WELWYN HATFIELD COUNCIL – DEVELOPMENT CONTROL
DELEGATED REPORT

APPLICATION No:	S6/2010/0094/LB
------------------------	------------------------

‘Replacement of corrugated asbestos cement roofing with lead sheet incorporating rooflights removal of redundant internal walls and raising level of part of floor. insertion of new french doors and sliding-folding doors into external walls.’

DRWG No 797.04
7 FORE STREET HATFIELD AL9 5AN
KITCHEN ALTS
Scales: 1:50, 1:20 @ A1
04 Dec 2009 Copyright RM Crump Ltd tel: 01763288491/email:rmcrump@btinternet.com

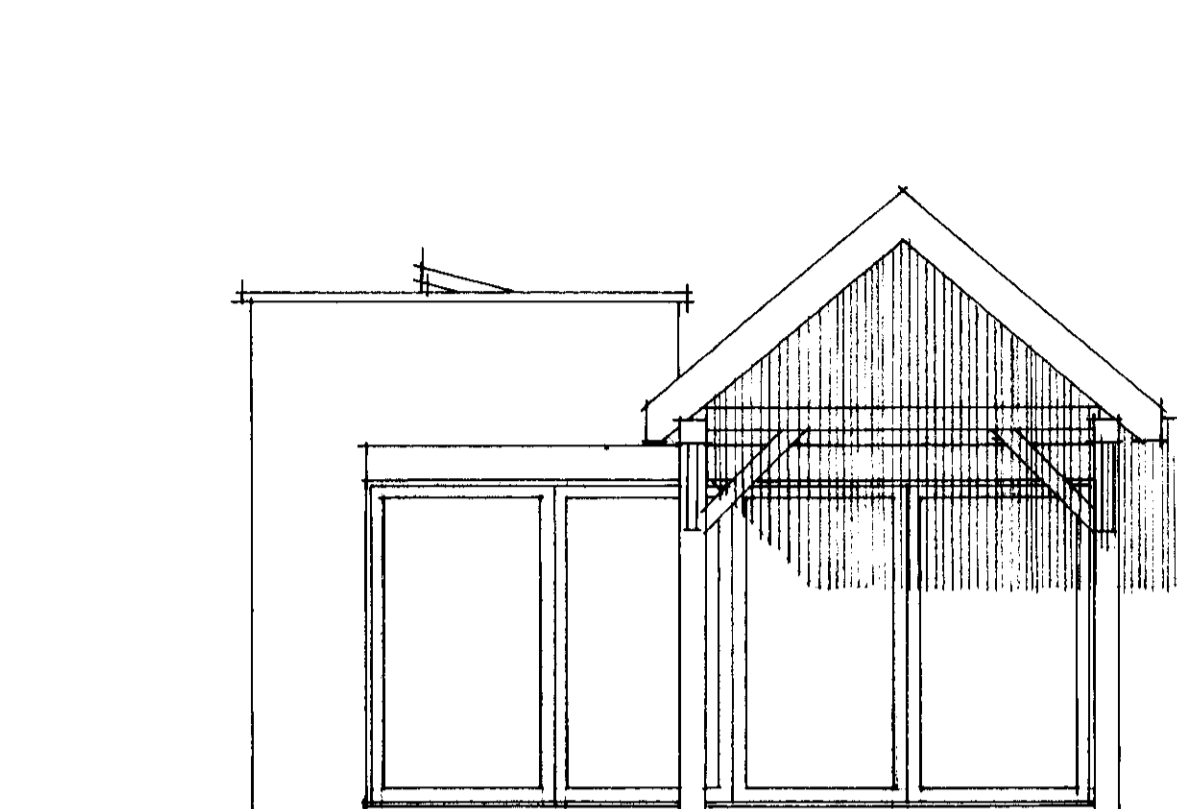
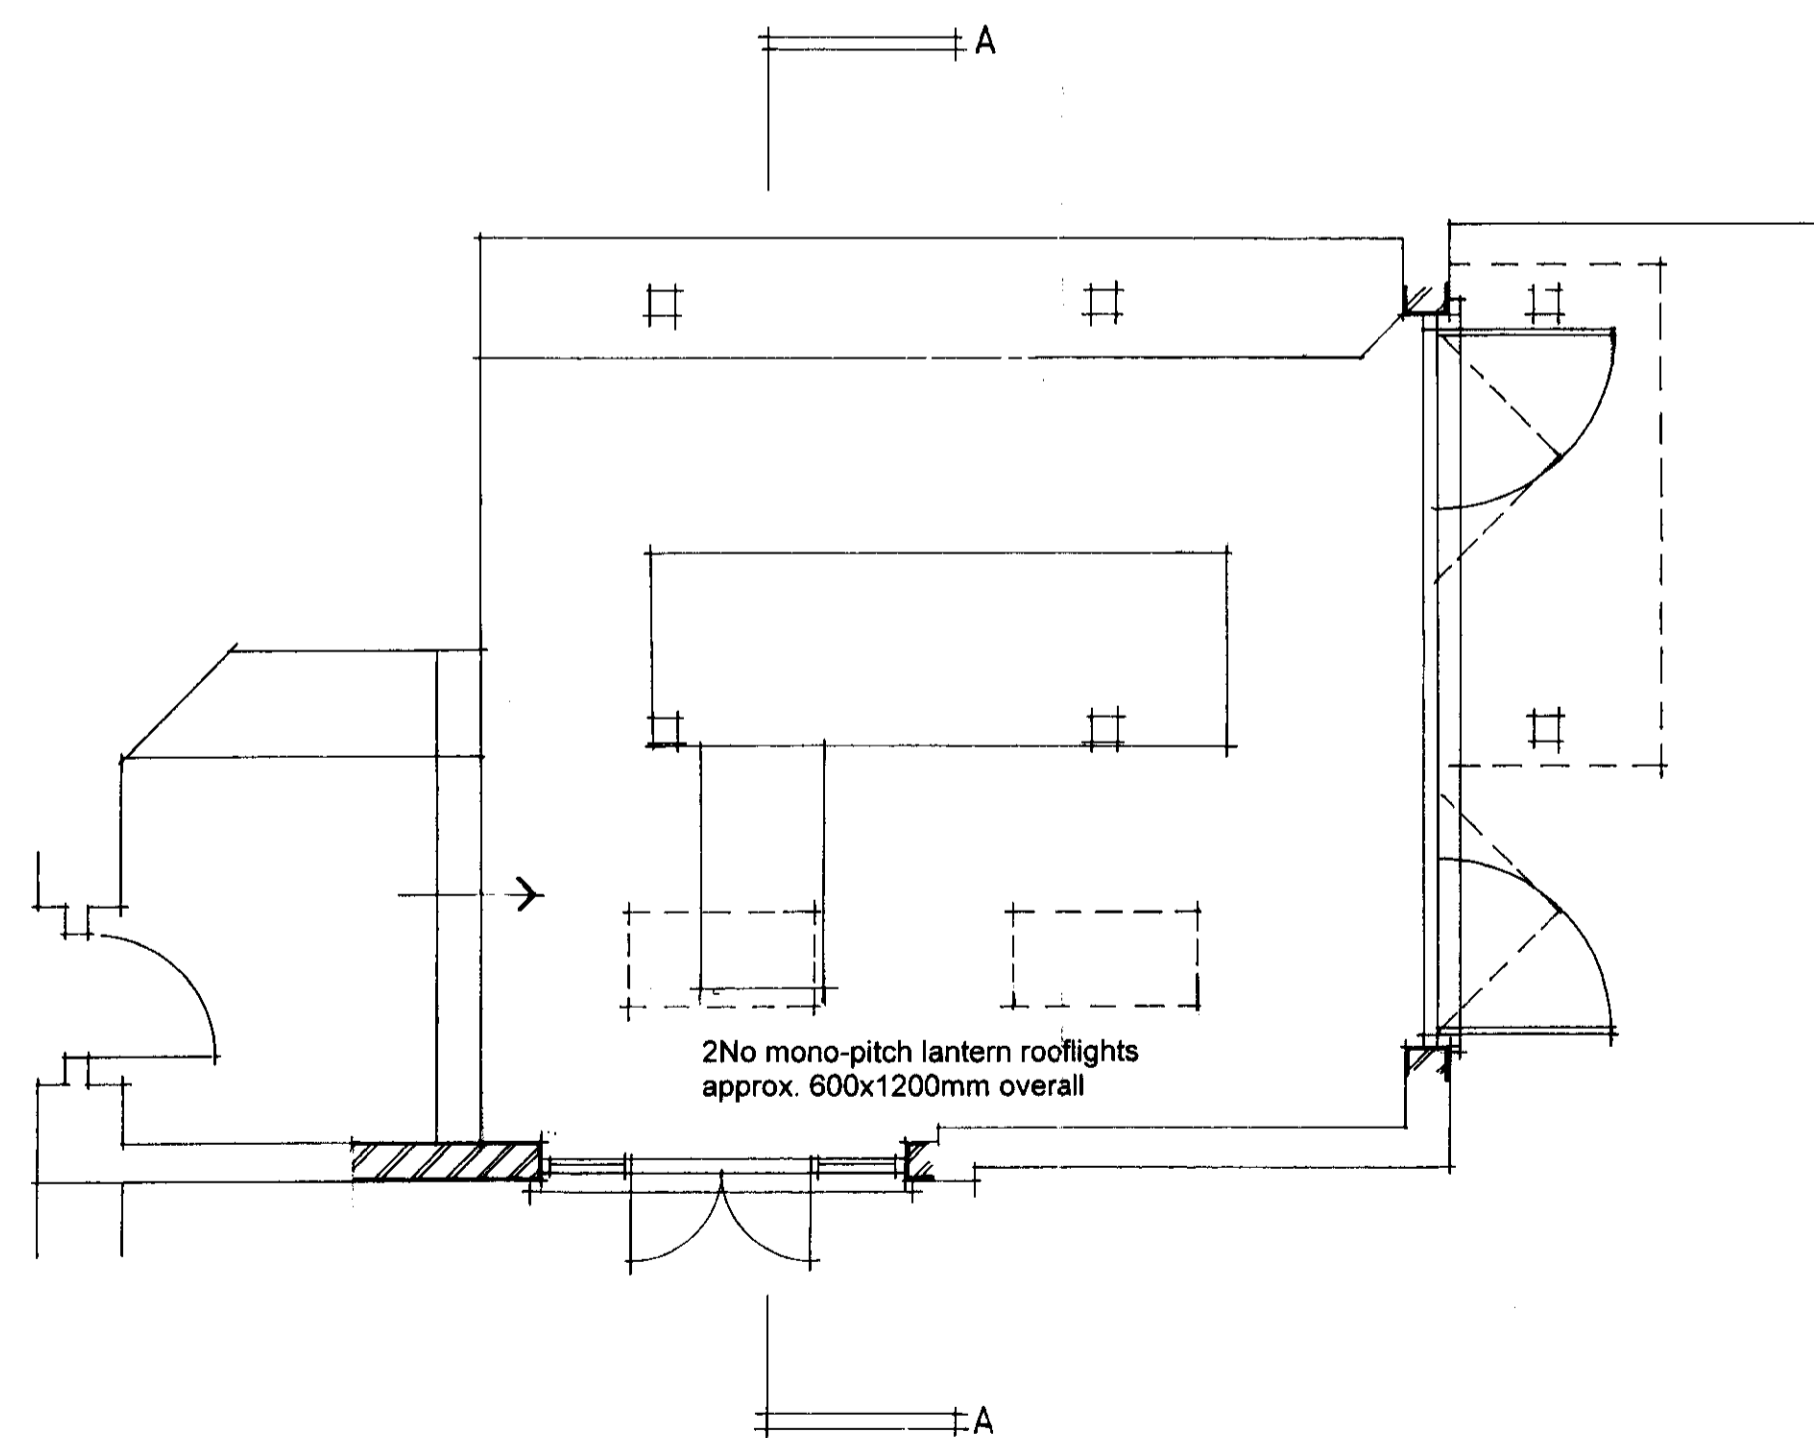
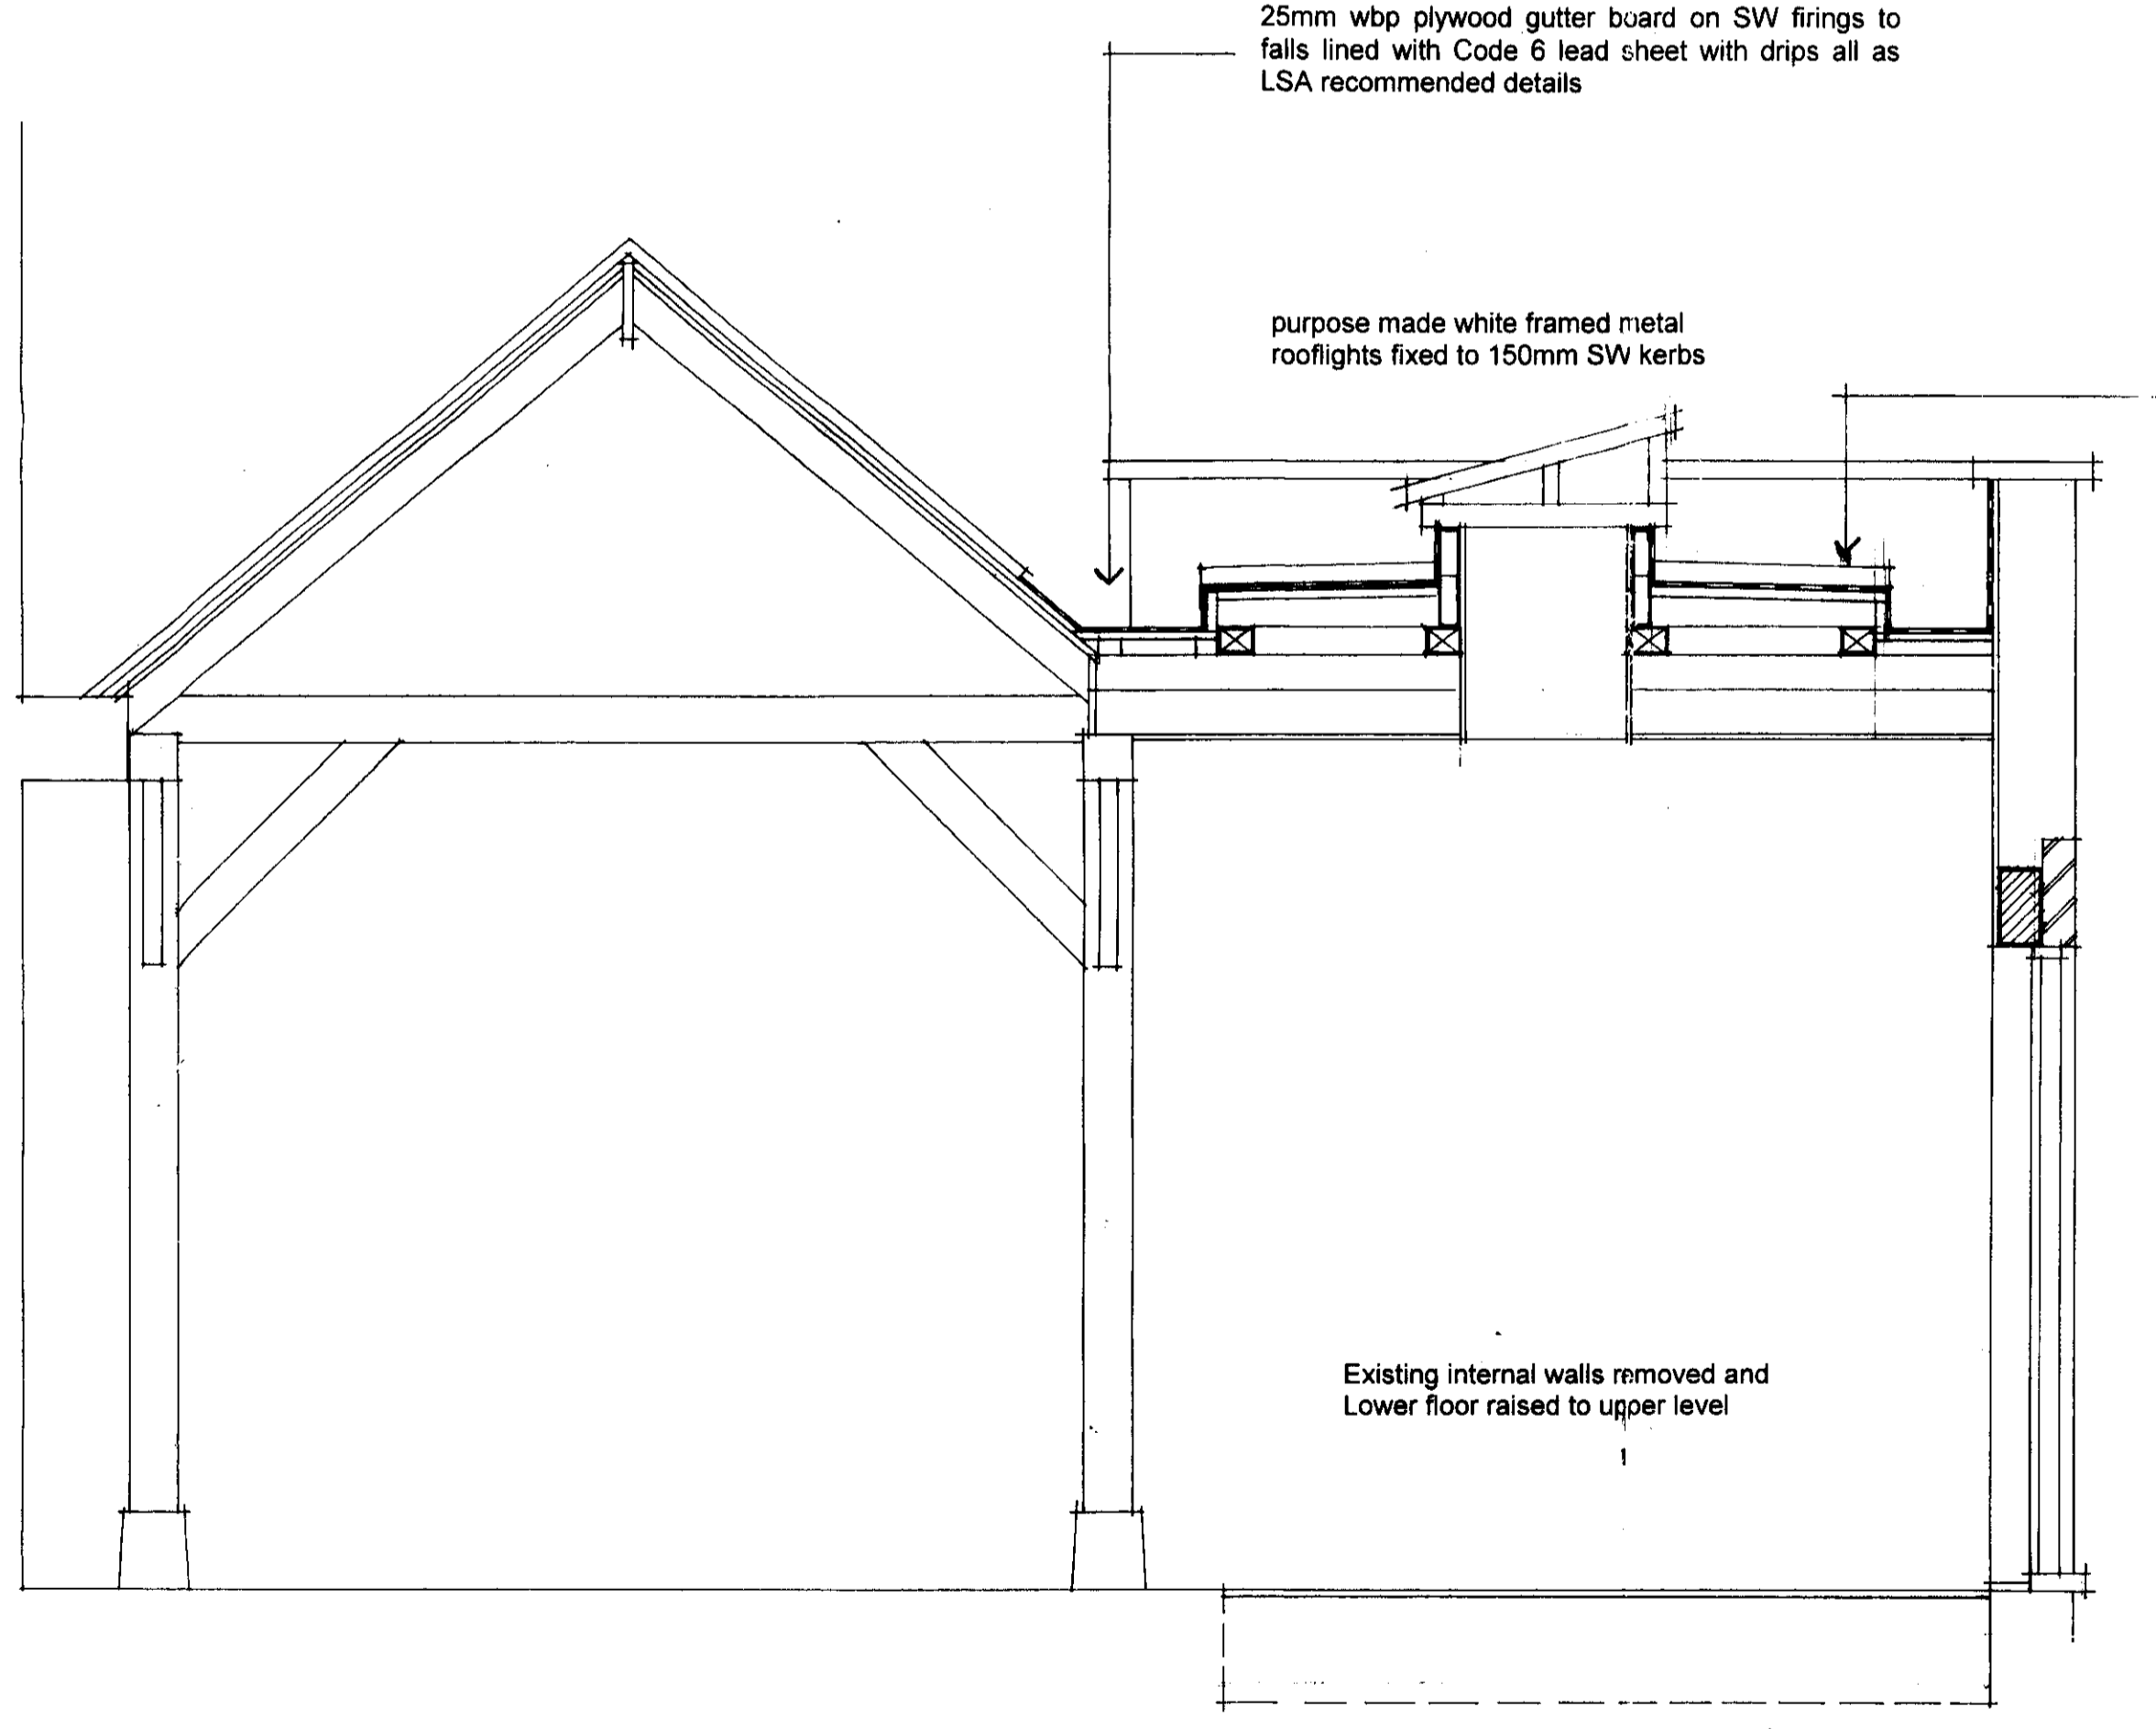
- 1.) The existing roof is of a poor quality and is only visible from the upper windows of the application property as it is concealed behind a brick parapet wall. The proposed use of code 6 lead roof with rooflights would be a significant improvement over the existing structure as it is not readily visible, there are no other issues raised with this proposal, subject to it being constructed to the details shown on approved drawing 797.04

- 2.) The removal of these walls is not considered to be an issue, as this structure is a later addition to the main house.
- 3.) The increase in floor height is again not considered to be an issue, as this area of the house is not considered to be original and would have no impact on the external appearance of the building.
The proposed new French doors and new folding sliding doors are also located in this new part of the building and although they would have an impact on the external appearance, they are both located in a more discrete part of the site and the folding doors slightly below existing ground level. Subject to the materials being of a high quality and this would require the framing to be in wood, and with a painted finish to match the main doors of the house, this would be acceptable. This can be subject to a planning condition.

4. The materials and mouldings for the proposed French doors as shown on approved drawings 797.04 & 797.06 are to used in the approved development. Any variation to these details and materials are to be approved in writing with the local planning authority.
